From: [REDACTED]
To: [Metrowest1](#)
Cc: [NI Enquiries](#)
Subject: Fwd: FAO MetroWest Phase 1 Case Team - Your Ref: TR040011
Date: 02 March 2021 11:52:53
Attachments: [Web Page.pdf](#)

Thank you for forwarding Richard Guyatts email which I have reviewed the have now found the revised 2017 proposal regarding access from Chapel Pill Lane which states a temporary compound and permanent access for maintenance, copy attached at the end of my email.

Drawing **PILL TUNNEL EASTERN PORTAL COMPOUND LANDSCAPING & ACCESS PLAN SHEET 1 OF 2**

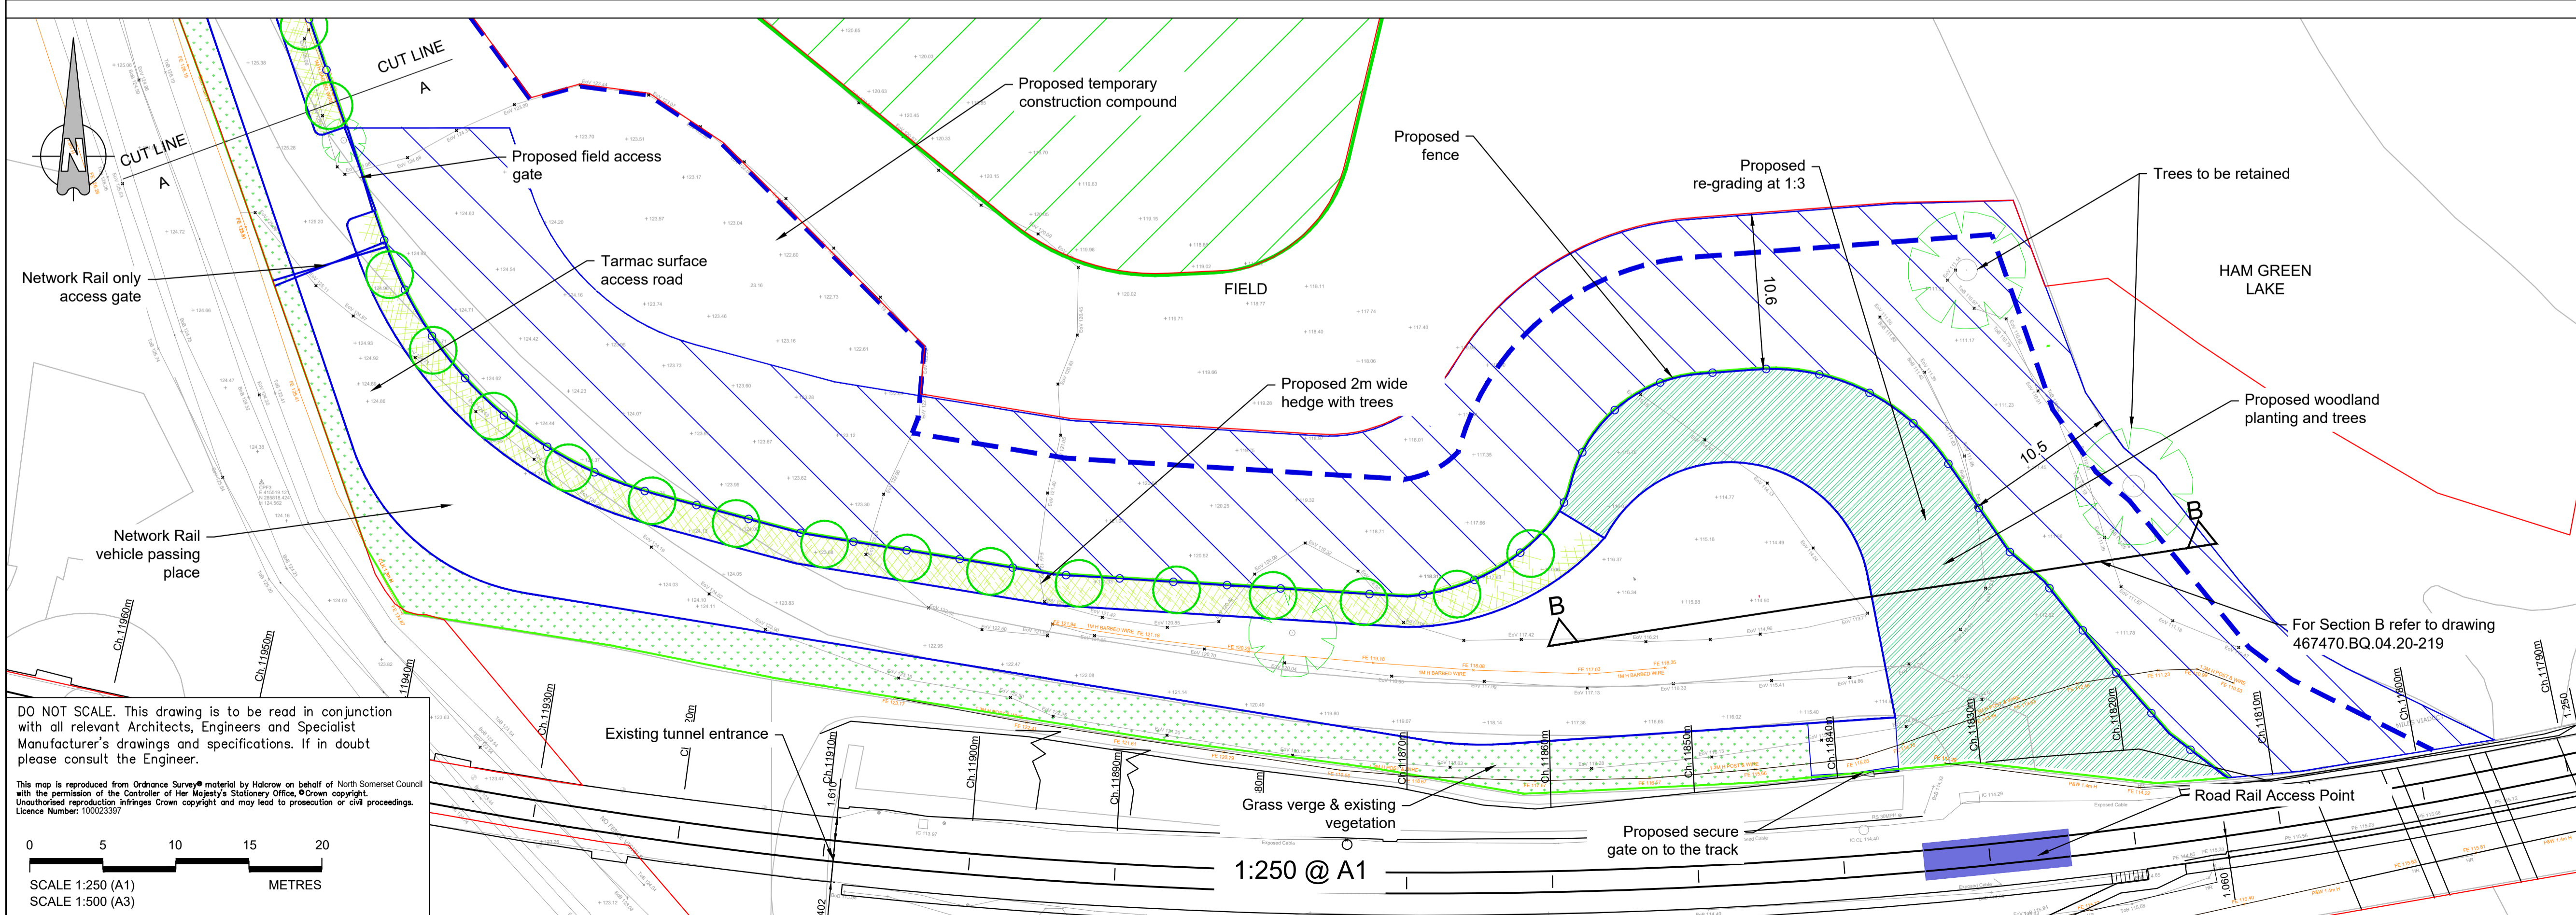
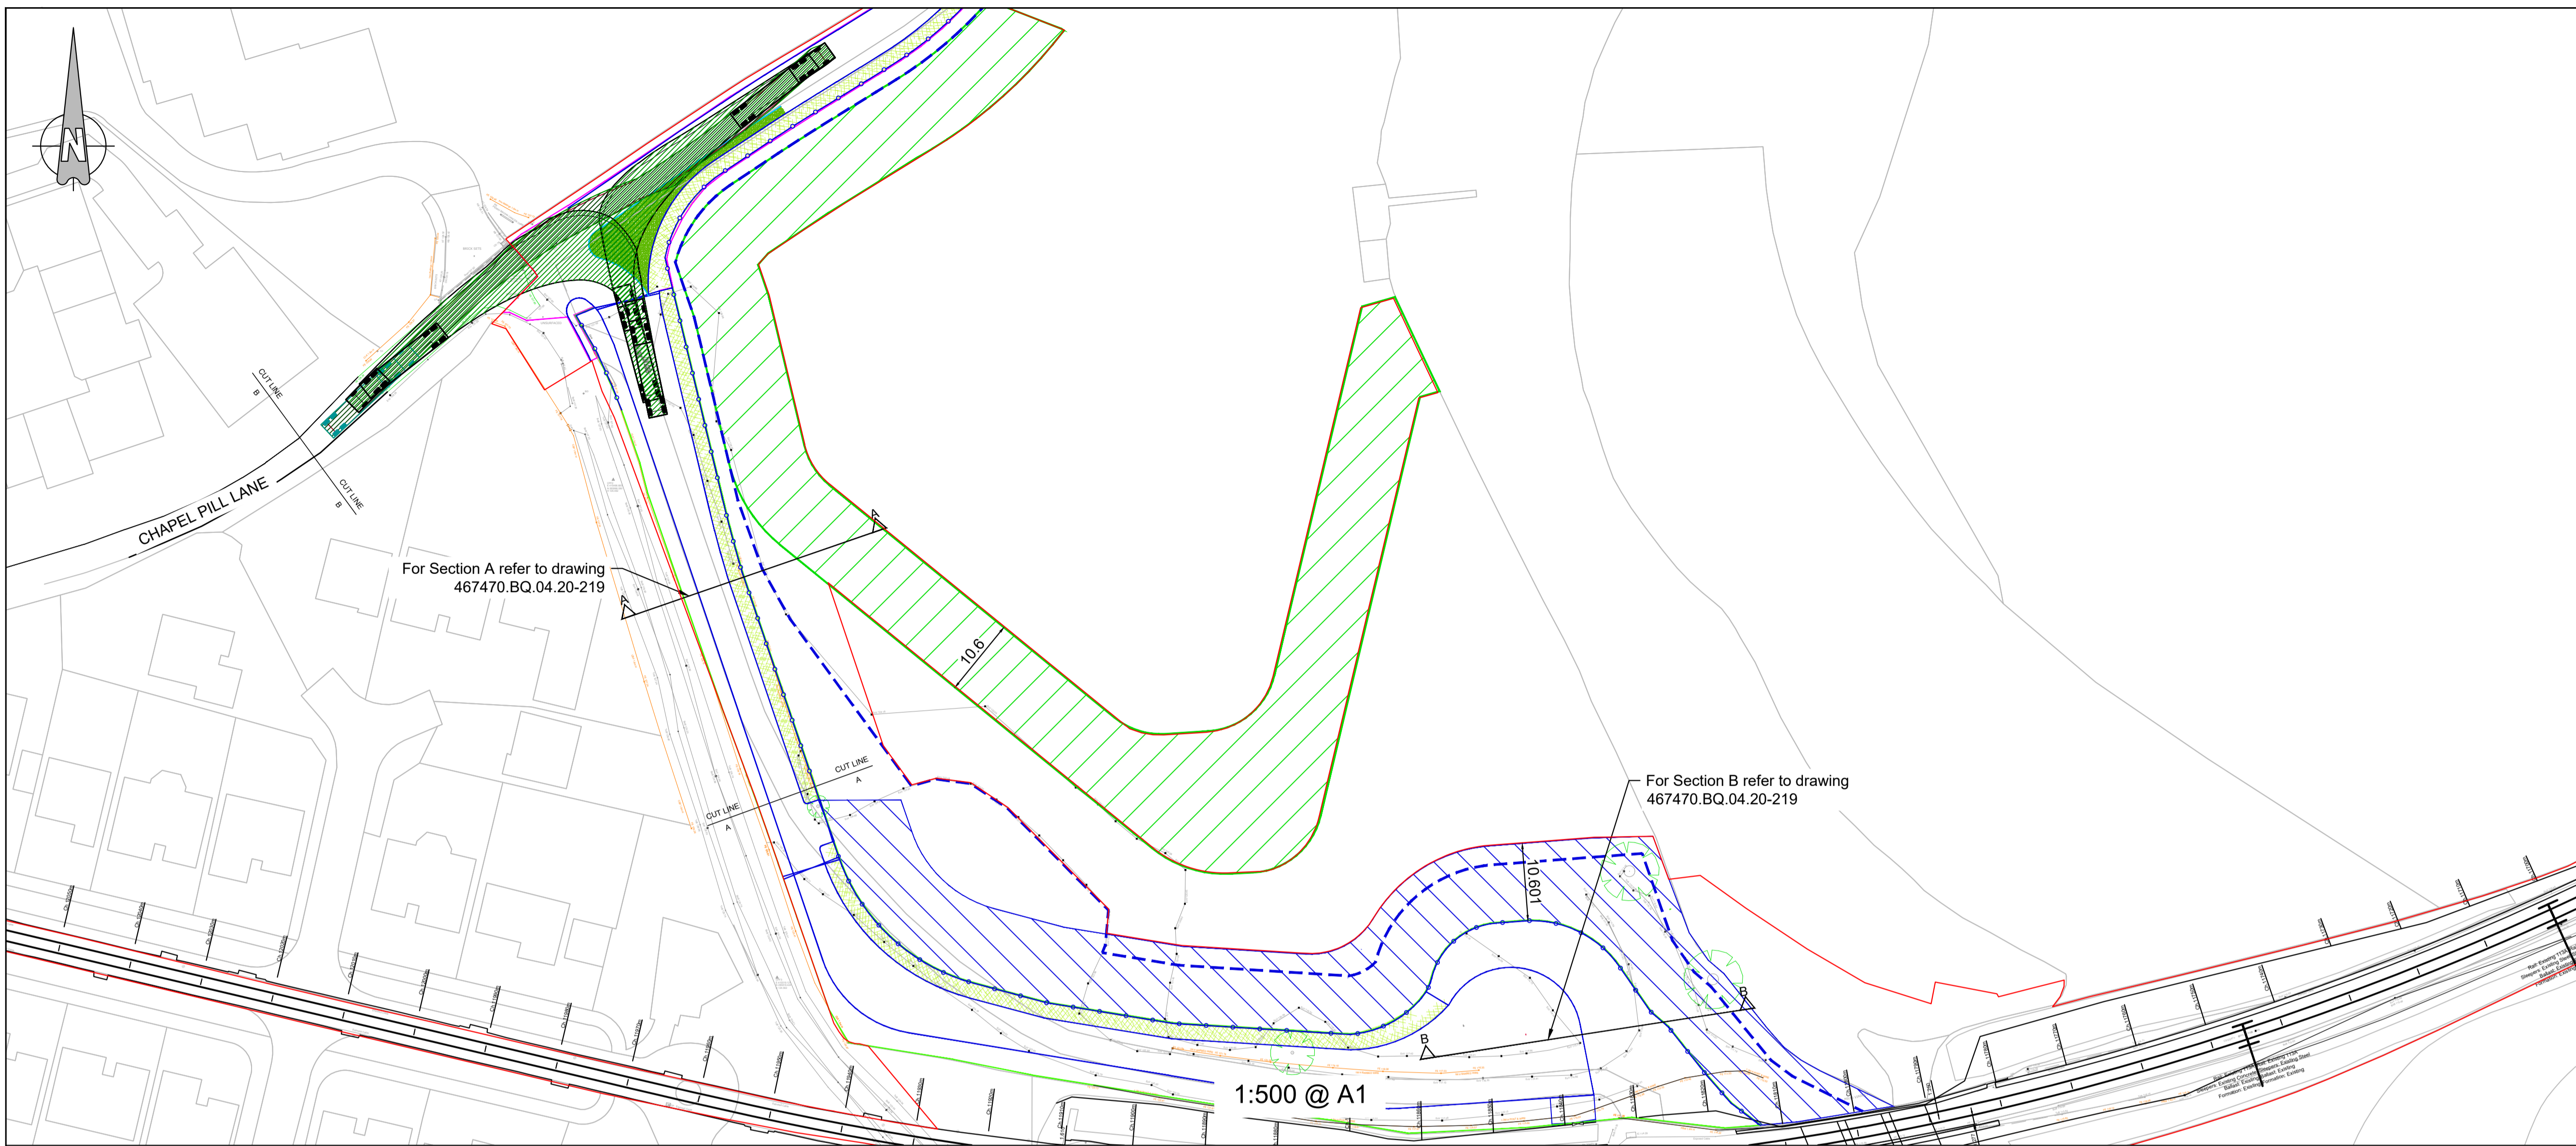
Whilst I understand the reason for the change of access required the proposal states this is a temporary compound and therefore, I cannot understand why a permanent road surface such as tarmac would be required.

Whilst the contractors may use the field for a temporary compound and parking vehicles etc. To access the rail track they will still require access via Hayes Mayes Lane as this runs across the top of the tunnel and provides a walkway down to the platform and access to the tunnel.

I was please to read that there will no permanent lighting and would suggest as previously suggested MetroWest use Hardcore as this will reduce the impact on the environment and greenbelt landscape.
